Application: SSI 7485

I write regarding the proposed modification to M4-M5 Link, Mod 2 The Crescent overpass and changes to pedestrian infrastructure in North Annandale, Rozelle and Rozelle Bay Foreshore area.

Figure 4-2 Pedestrian and cyclist bridge infrastructure options

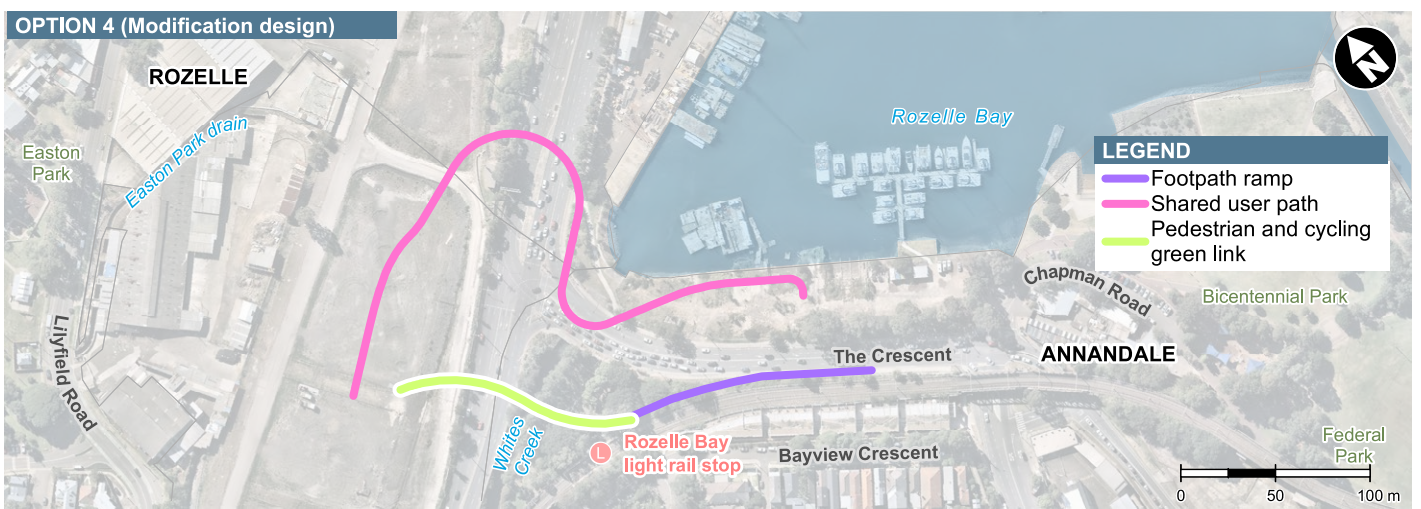
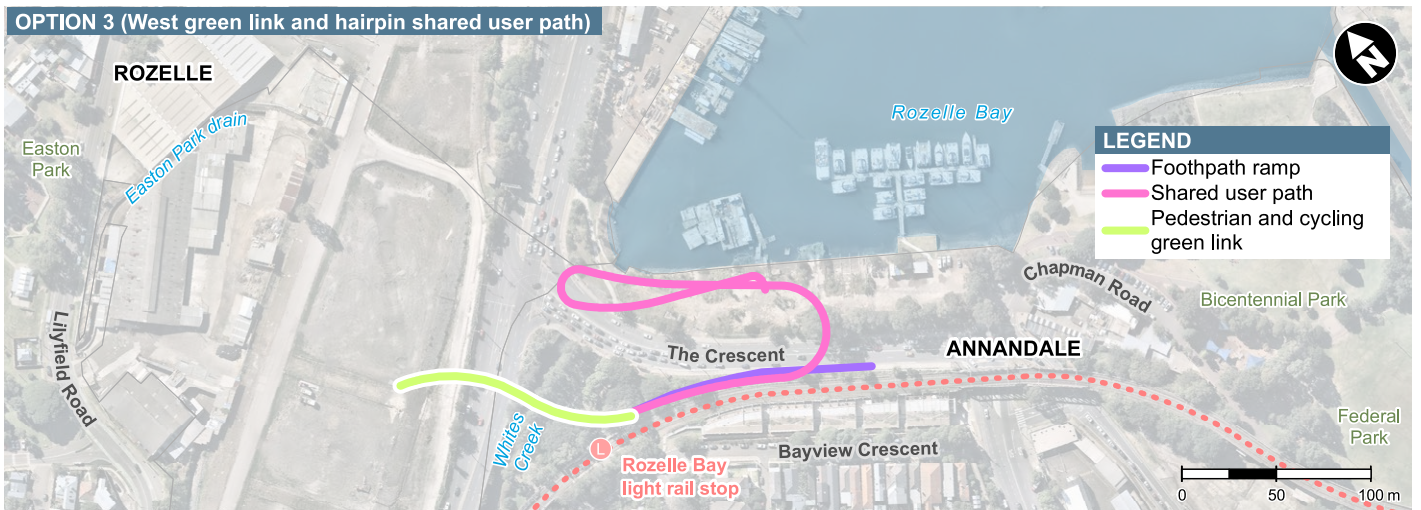
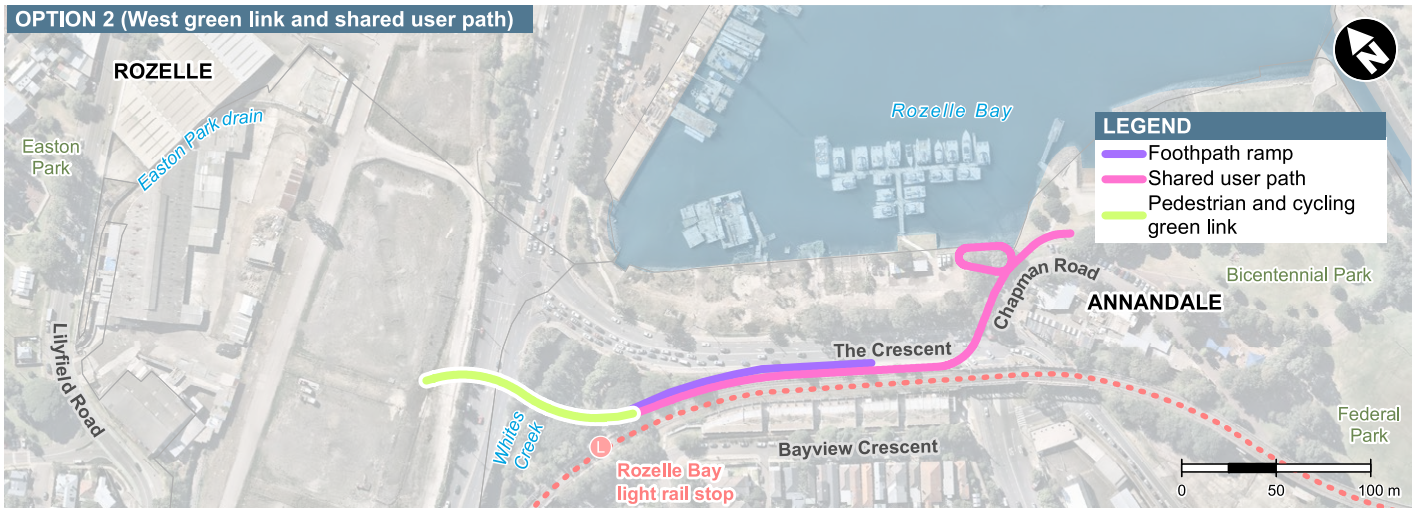
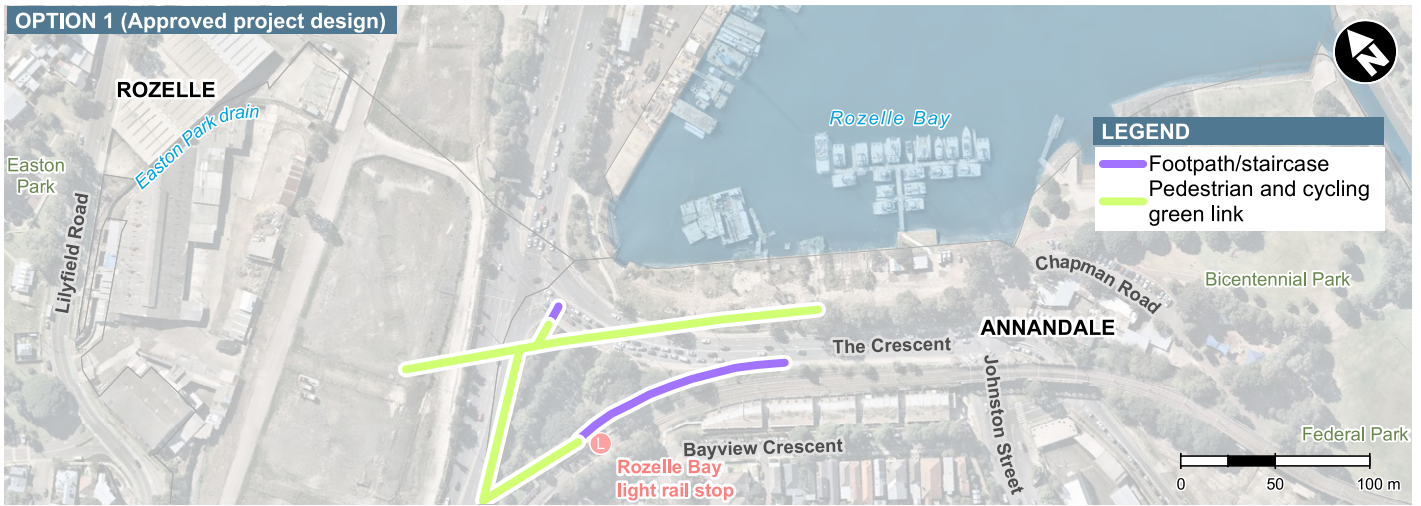
I request RMS work with the community to explore alternate design options to the proposed new car overpass design and the changed pedestrian and cyclist links. I am seeking the reinstatement of the safe, direct access from the approved EIS GreenLink to create a continuous green open space connection from the Rozelle Rail yards and Annandale to the foreshore. The GreenLink was more than just a walk way - it put people central to the design, maximising safety, and providing much needed accessible open space for the community now and into the future Bays Precinct design.

- The significantly reduced safety and increased risk for pedestrians and cyclists with removed access over The Crescent to Bicentennial Park and the increased traffic along Johnson Street.
- Being required to cross five sets of pedestrian lights at The Crescent as my option to reach the foreshore from Annandale or from Rozelle Bay light rail stop.
- Removal of direct active links to the foreshore, cutting the community off from the area and the proposed revitalisation of the entire Bays Precinct, including linking the Light Rail and Bus stops to a Ferry wharf and Metro station.
- Urban and landscape design that is being built before a finalised Masterplan for the area.
- Traffic changes that limit movements around the suburb and create further congestion in the local streets of Annandale, Forest Lodge, Glebe, Lilyfield and Rozelle with no planning to deal with these.

- Reinstate the GreenLink connecting communities and green open space from Rozelle to Bicentennial Park
- Relocate and design pedestrian and cyclist connections that are continuous, safe and direct.
- Design the modification infrastructure and active links in response to the character of the suburbs, the location of the foreshore and it's potential future development.
- Provide pedestrian and cyclist paths that maximise people safety and do not force them onto busier streets, unsafe concrete plazas and caged walkways.
- Integrate active and direct connections to all active transport - including the future Metro West and Foreshore Ferry Wharf
